CITY OF ALBUQUERQUE

Re: NMAC Building
1330 Cuesta Abajo
Traffic Circulation Layout
Engineer's/Architect's Stamp dated 1-20-16 (D16-D02F)

Based upon the information provided in your submittal received 2-5-16, the above referenced plan cannot be approved for Building Permit until the following comments are addressed:

TRAFFIC CIRCULATION LAYOUT 1" = 25'-0"

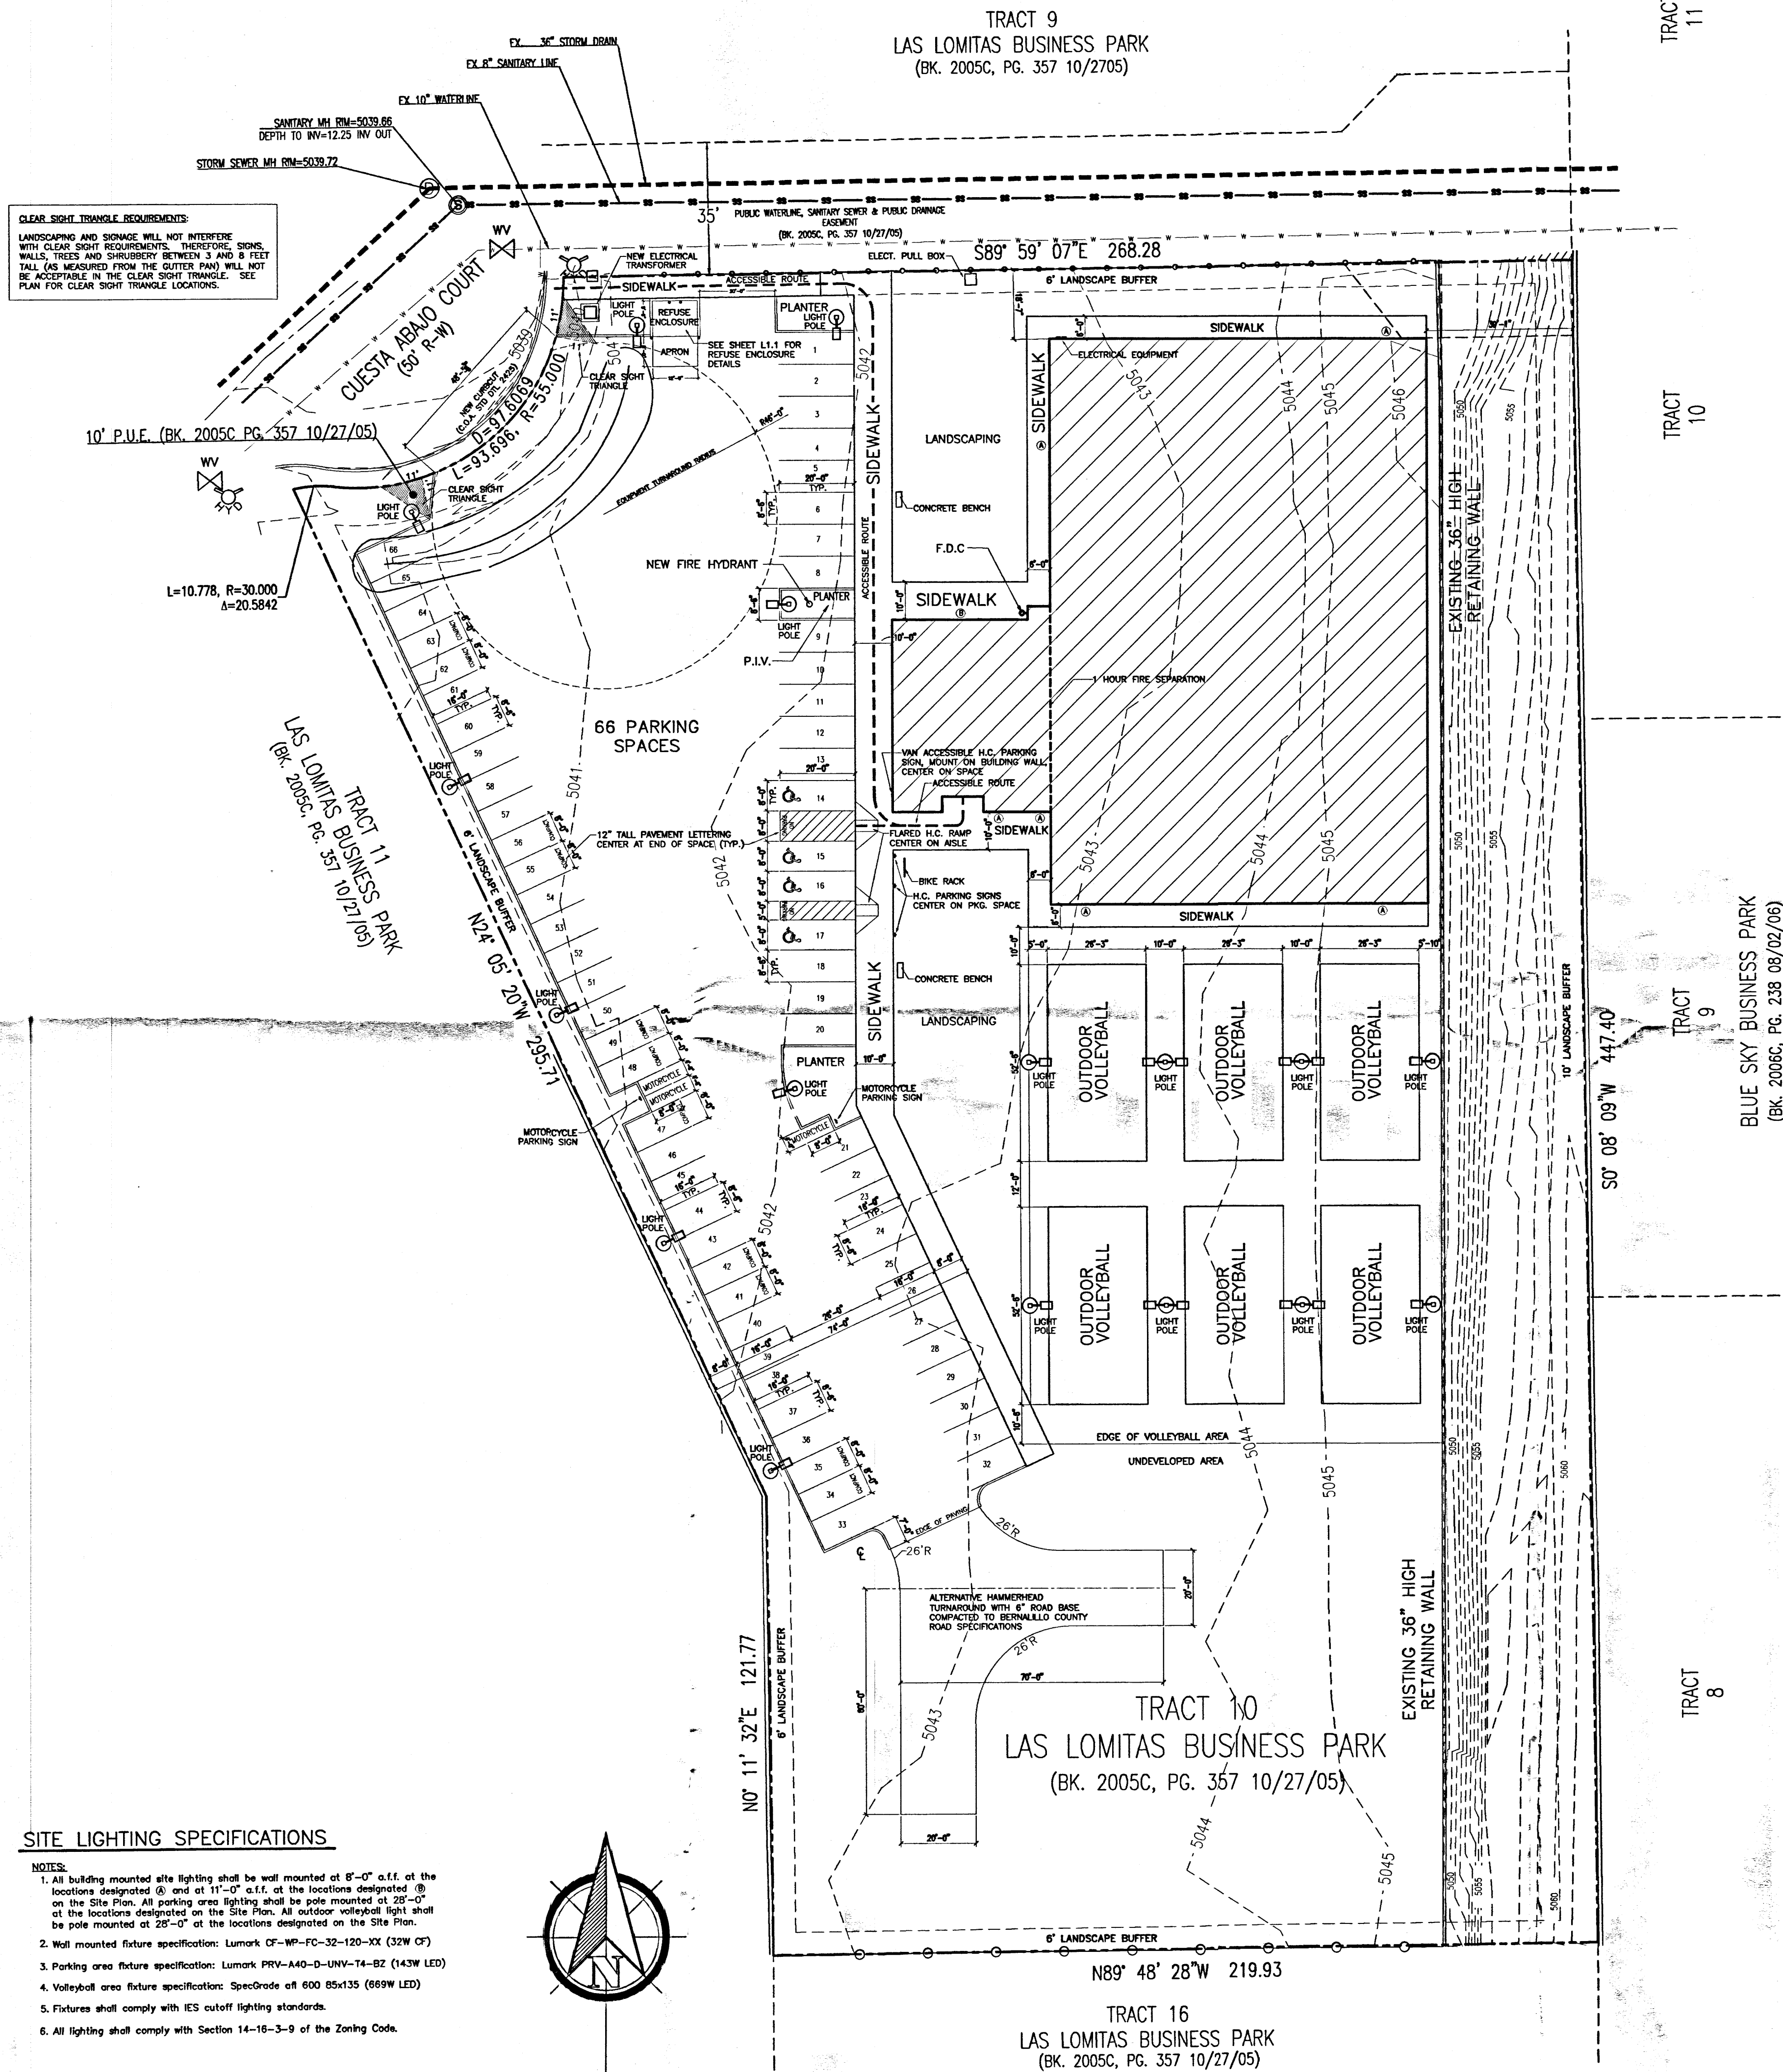
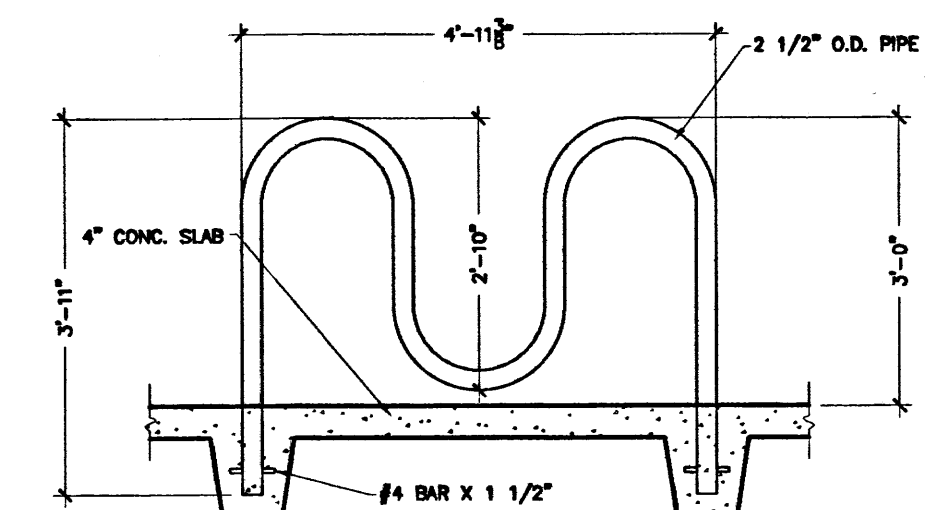
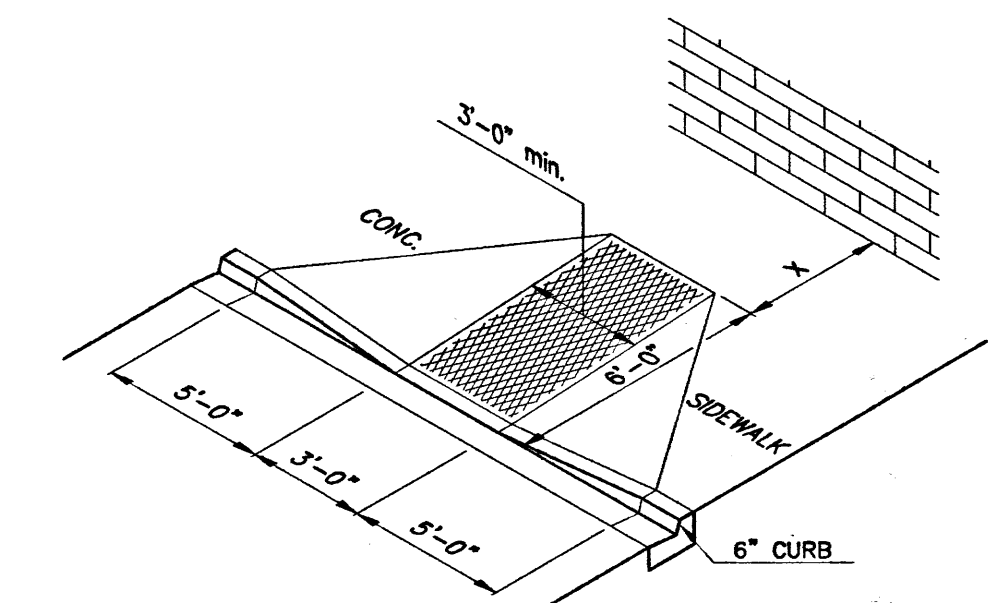
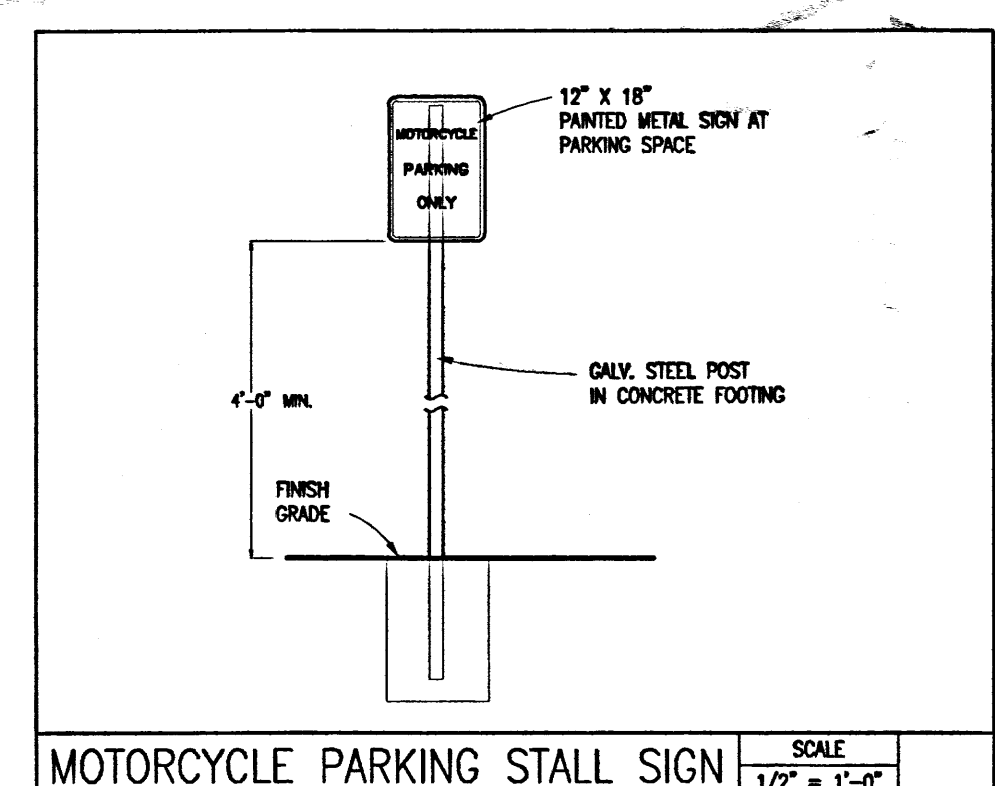
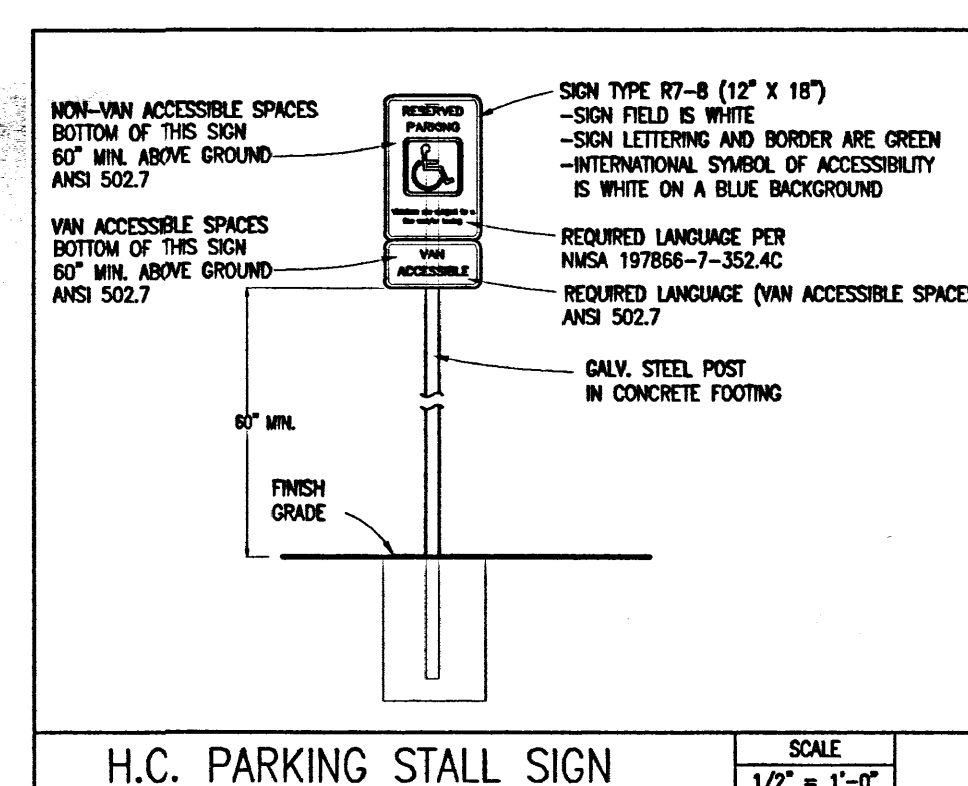
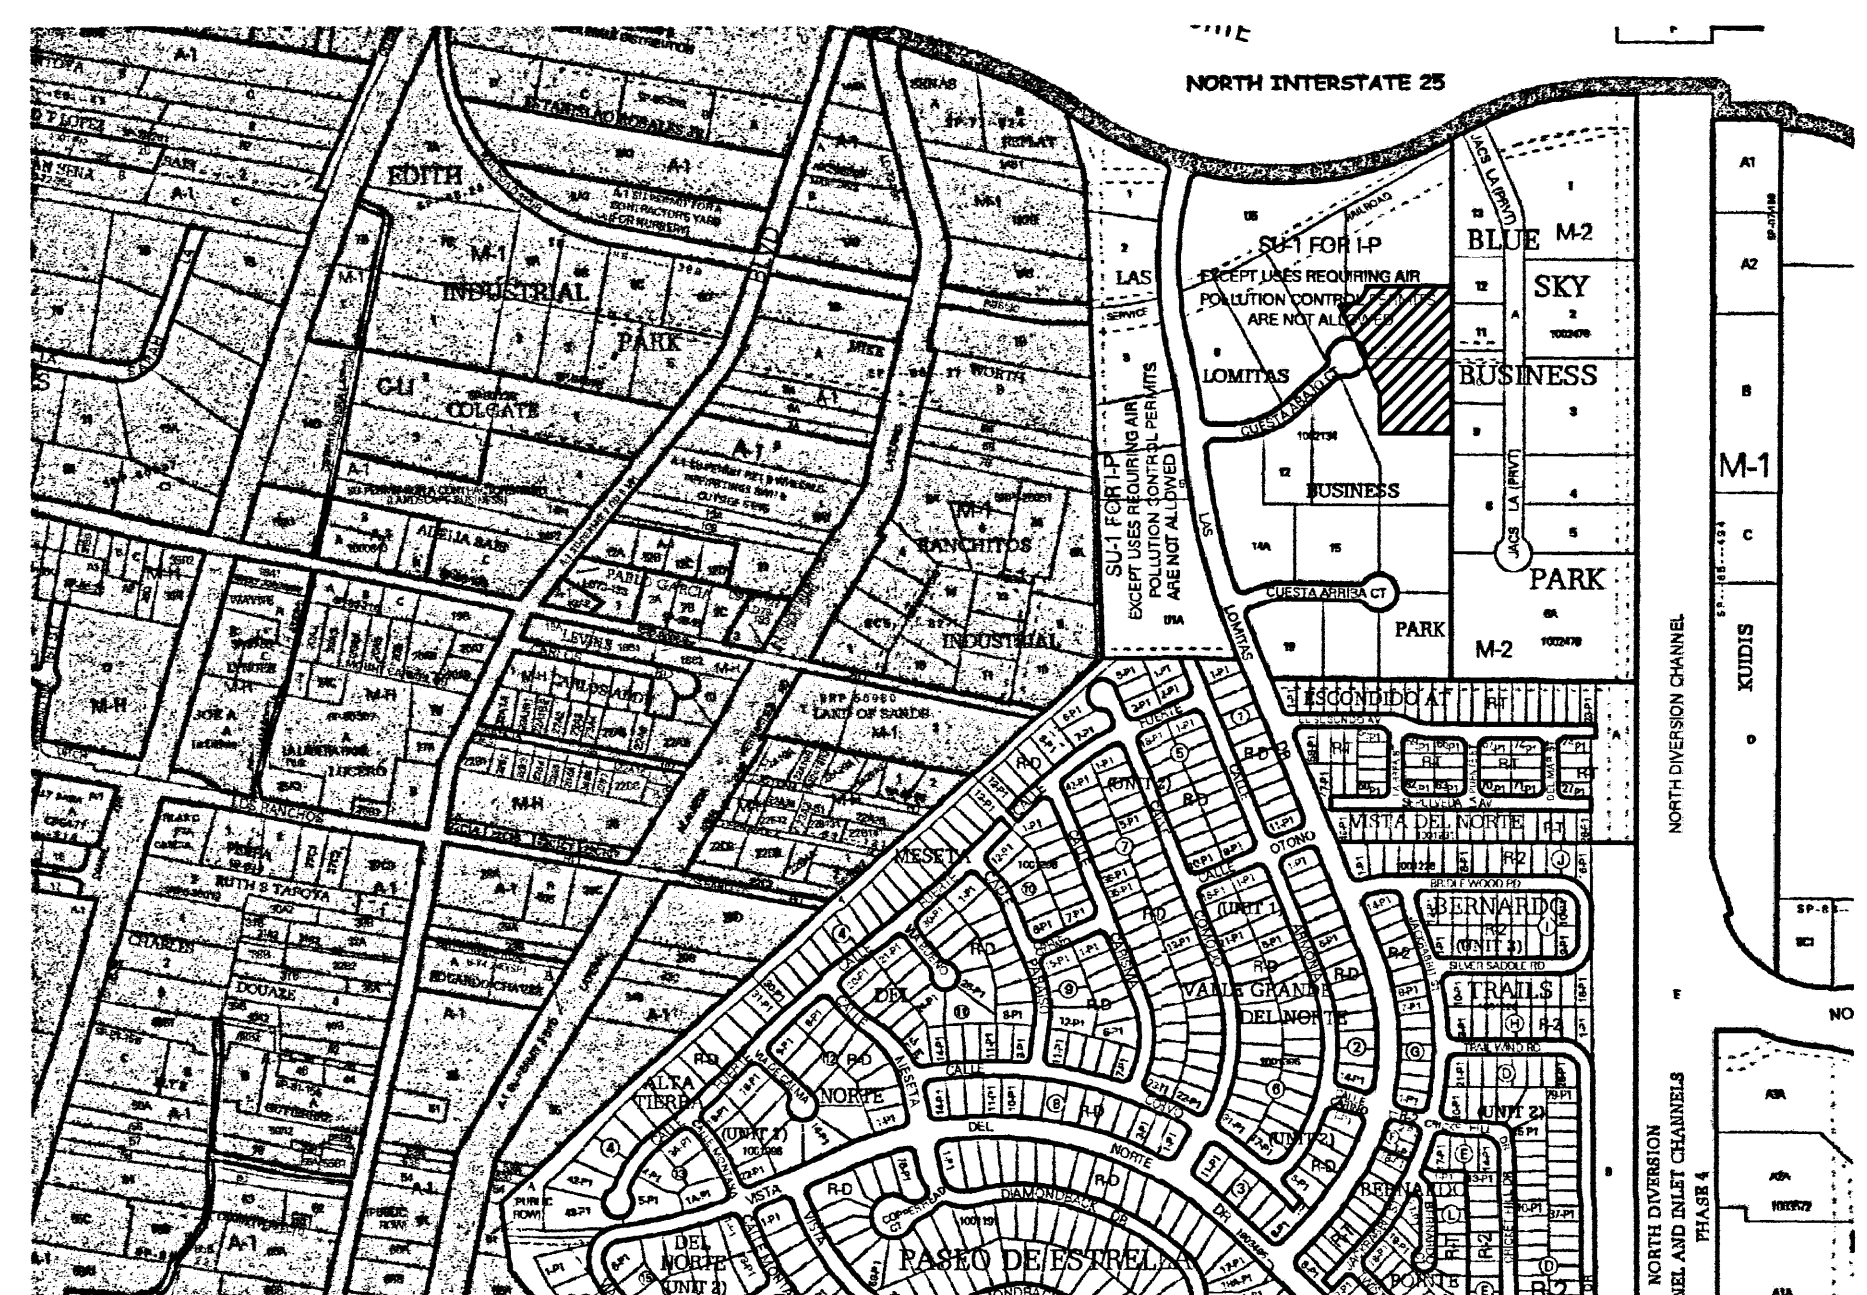
1. Please identify all existing sidewalks, curbs, drive pads on Cuesta Abajo Ct. and anything that influences the parking and circulation on the site.
2. Identify the right of way width, medians, curb cuts, and street widths on Cuesta Abajo Ct.

3. Please list the width and length for all parking spaces. Detail parking overhang into landscape and pedestrian walkways.
4. Label the compact parking spaces by placing the words **"COMPACT"** on the pavement of each space.

5. Parking is not permitted in front of the Fire Department Connection (FDC) and there shall be no obstructions within 15 ft. of a fire hydrant. The section of the site plan that calls out for a planter and the two adjacent parking spaces will need to be reconfigured, along with the parking calculations.

6. Per the DPM, a 6 ft. wide ADA accessible pedestrian pathway is required from the public sidewalk to the building entrances. Please clearly show this pathway and provide details of ADA approved ramps from Cuesta Abajo Ct.

7. All sidewalks along streets should be placed at the property line.
8. Provide a min 6" or max 8" high concrete barrier curb or other acceptable barrier between landscaping and parking areas and/or drive aisles. Please call out curb detail.

9. Design delivery vehicle route needs to be shown.
10. Service vehicle and/or refuse vehicle maneuvering must be contained on-site; provide a copy of refuse approval.

11. All broken or cracked sidewalk must be replaced with sidewalk and curb & gutter. A build note must be provided referring to the appropriate City Standard drawing.
